Engineers Comments Regarding Surface Water Drainage

Application Reference:	AL/30/26/DOC	Reviewer Reference:	ADC/EXT5/AF
Planning Officer:	Simon Davis	Date of Review:	06/10/2026
Site Name:	Land at Bayards Level Mare Lane Eastergate PO20 3RZ		
Application Description:	Approval of details reserved by condition imposed under AL/113/21/OUT relating to condition 24-as built drawings.		
Assessment Number:	1

Response	Condition 24: Further information required
-----------------	---

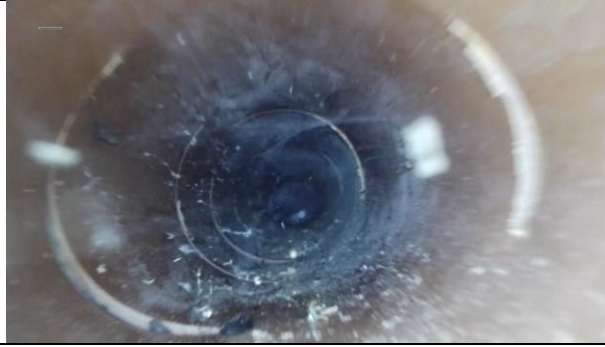
ADC Drainage Comments	Designer Response			
Date:	06/10/2026				
Condition Number:					
Comment Number					
1.	Area 2. The verification report para 4.5-4.8 notes defects in the soakaway installation but not whether remedial works have been completed.				
2.	Area 2. The verification report notes that there is no evidence of the permeable paving installation in this area. This is a large area of permeable paving including the whole carriageway and parking areas.				
3.	Area 3. The verification report para 4.4-4.10 notes defects in the soakaway installation but not whether remedial works have been completed.

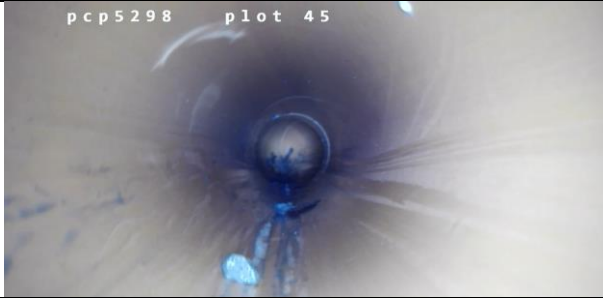
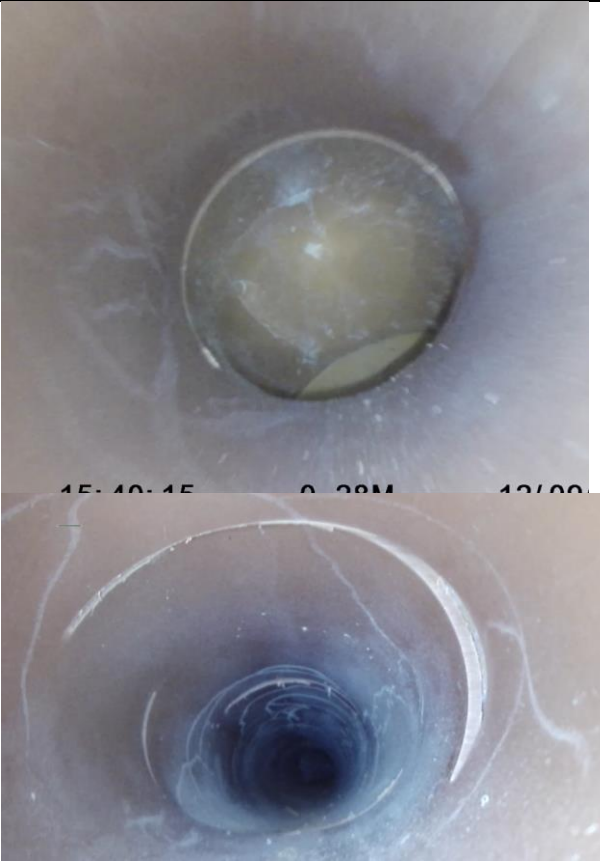
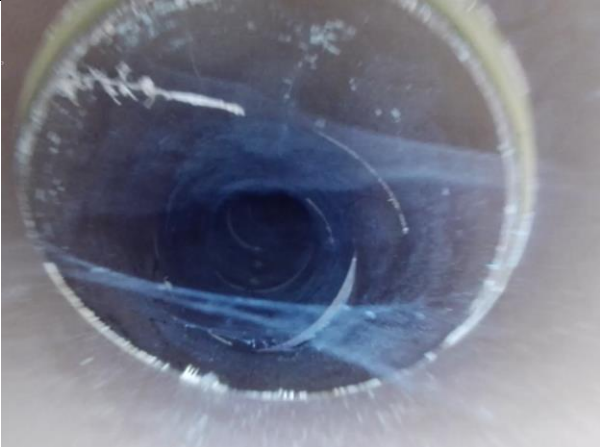
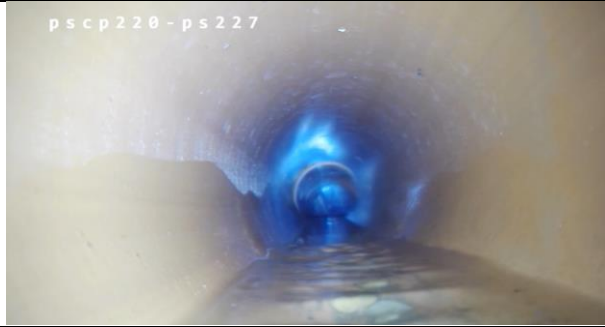
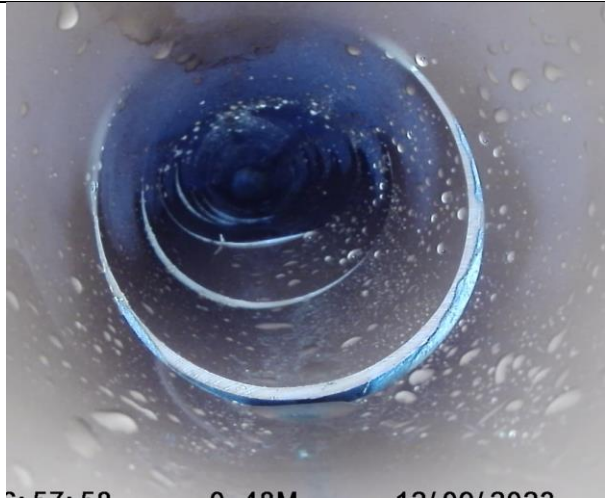
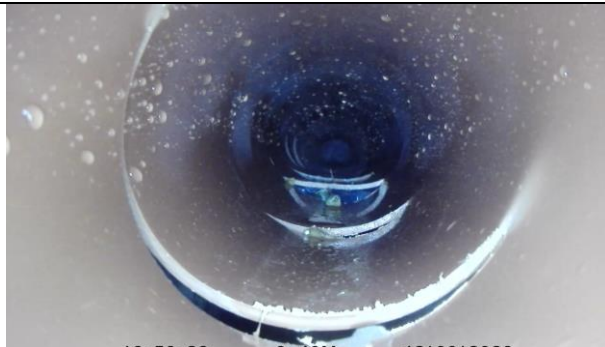
4.	Area 3. There are areas of permeable paving which are not evidenced in the verification report including parking areas.				
5.	Area 3. The road drainage soakaway is not evidenced in the verification report. The downstream defender should also be evidenced.				
6.	Area 3. The CCTV survey indicated defects and it is not clear from the verification report whether remedial works have been undertaken.				
7.	Area 4. The verification report para 4.4-4.10 notes defects in the soakaway installation but not whether remedial works have been completed.				
8.	Area 4. There are areas of permeable paving which are not evidenced in the verification report including parking areas.				
9.	Area 4. The road drainage soakaway is not evidenced in the verification report. The downstream defender should also be evidenced.				
10.	Area 6. The verification report notes that the soakaway installations are

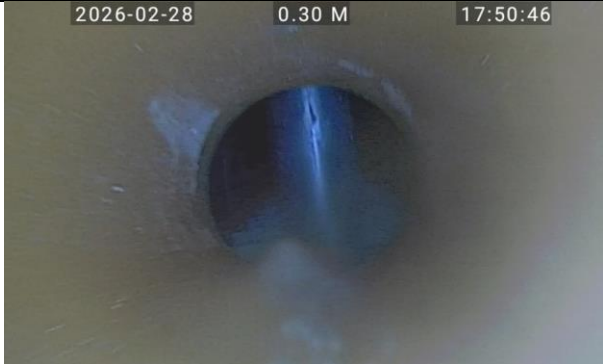
not evidenced and cannot be verified.				
11.	Area 7. The verification report para 4.4-4.10 notes defects in the soakaway installation but not whether remedial works have been completed.				
12.	Area 7. The verification report notes that there is no evidence of the permeable paving installation in this area. This is a large area of permeable paving including the driveway and parking areas.				
13.	Note – It is particularly concerning that the contractor may have installed soakaways with impermeable membrane thereby containing the runoff. This will lead to flooding and should be remedied as soon as possible.				
14.	Note - The verification report for Area 1 notes the Downstream Defender is not yet installed. This should be evidenced as part of any revisit.
